WEST SUSSEX COUNTY COUNCIL CONSULTATION

TO:	Arun District Council FAO:K Welch
FROM:	WSSC – Highways Authority
DATE:	23 October 2025
LOCATION:	Arun Self Storage Littlehampton Marina Ferry Road Littlehampton BN17 5DS
SUBJECT:	LU/173/25/PL Change of use from caravan storage to the storage of caravans, large vehicles such as heavy goods vehicles and trailers. This application is in CIL SD4 and is Zero Rated. Land drainage consent information received.
DATE OF SITE VISIT:	n/a
RECOMMENDATION:	No Objection /More Information

Low Loader Access Tracking

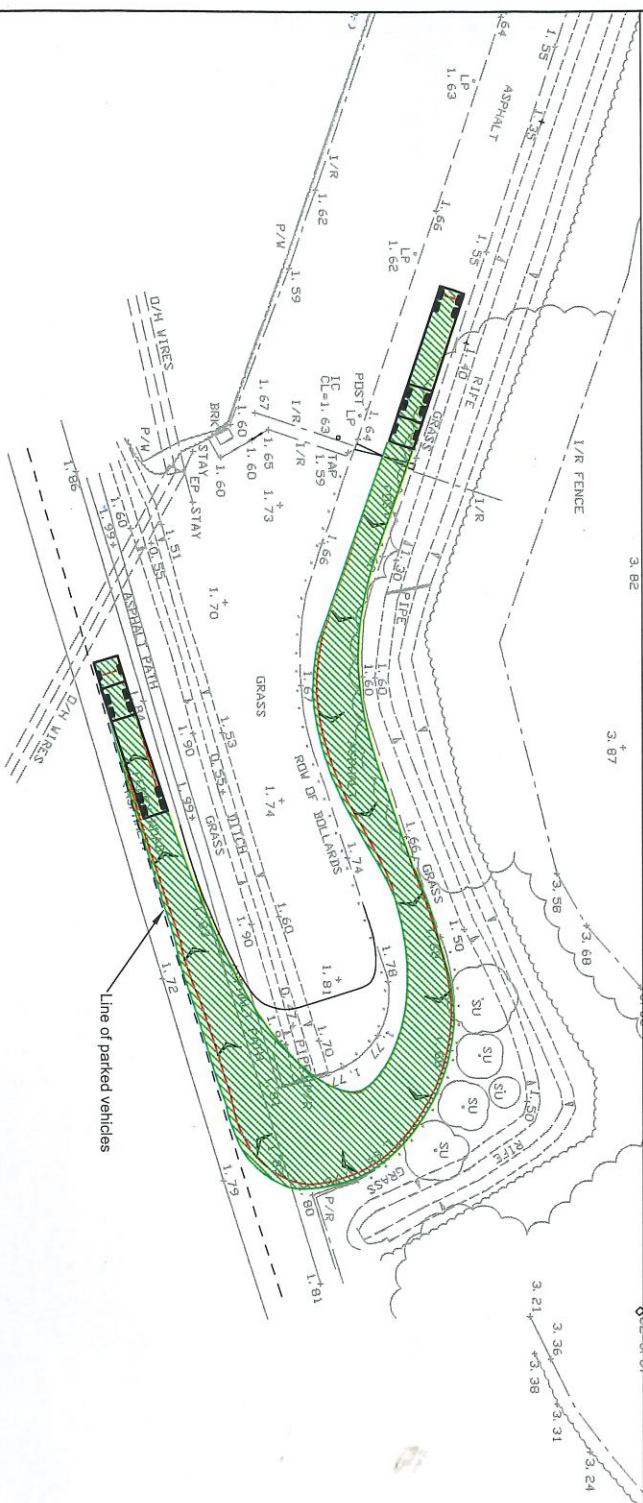
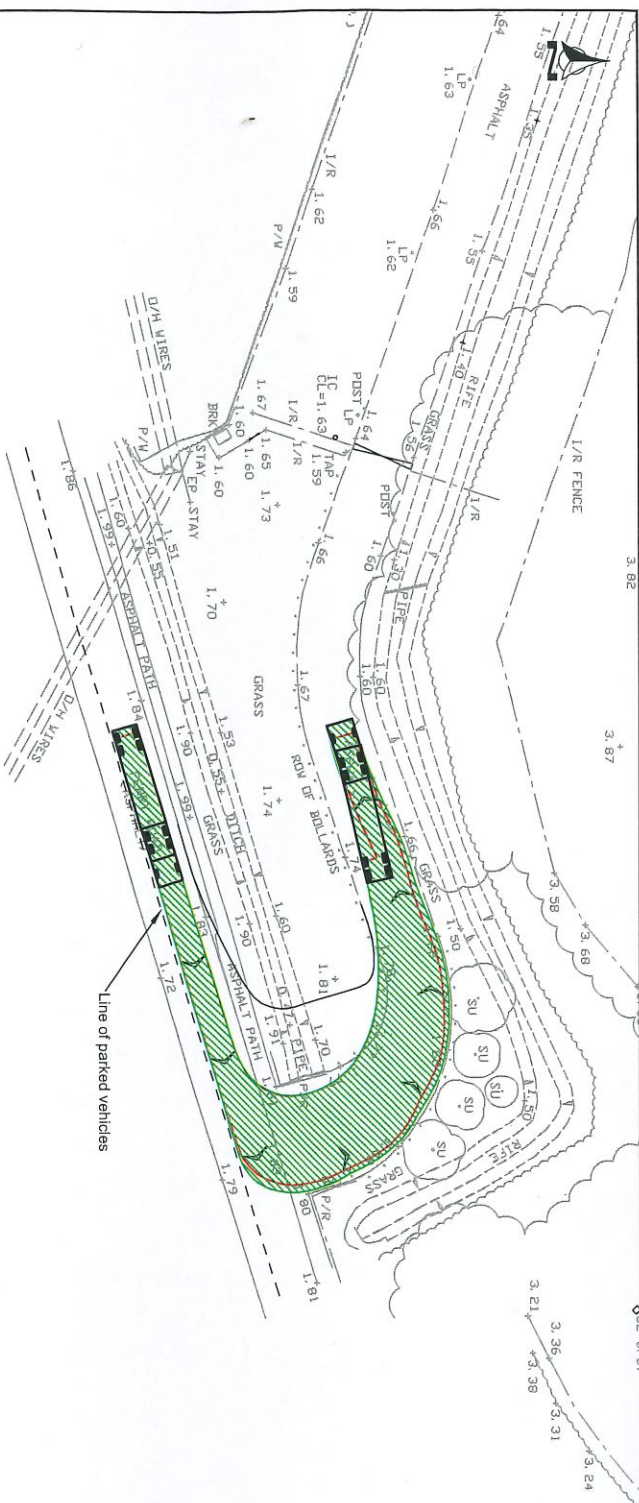
It is proposed for the access to be widened. Information regarding the widening of the access has been provided along with HGV tracking plots.

The tracking plots show that it is possible to enter and exit the site, however the line of parked cars, which appear to be a permanent occurrence, makes these manoeuvres very difficult. In addition, there do not appear to be any plans on the webpage relating to the widening of the access as a result of the Drainage Works.

The access onto Ferry Road needs addressing. In order for safe ingress and egress the parking on the opposite side of the road will need addressing by the application and approval of a Traffic Regulation Order (TRO).

- 1 The commitment to apply for a TRO
- 2 A plan showing the proposed parking layout
- 3 A plan showing the widening of the access
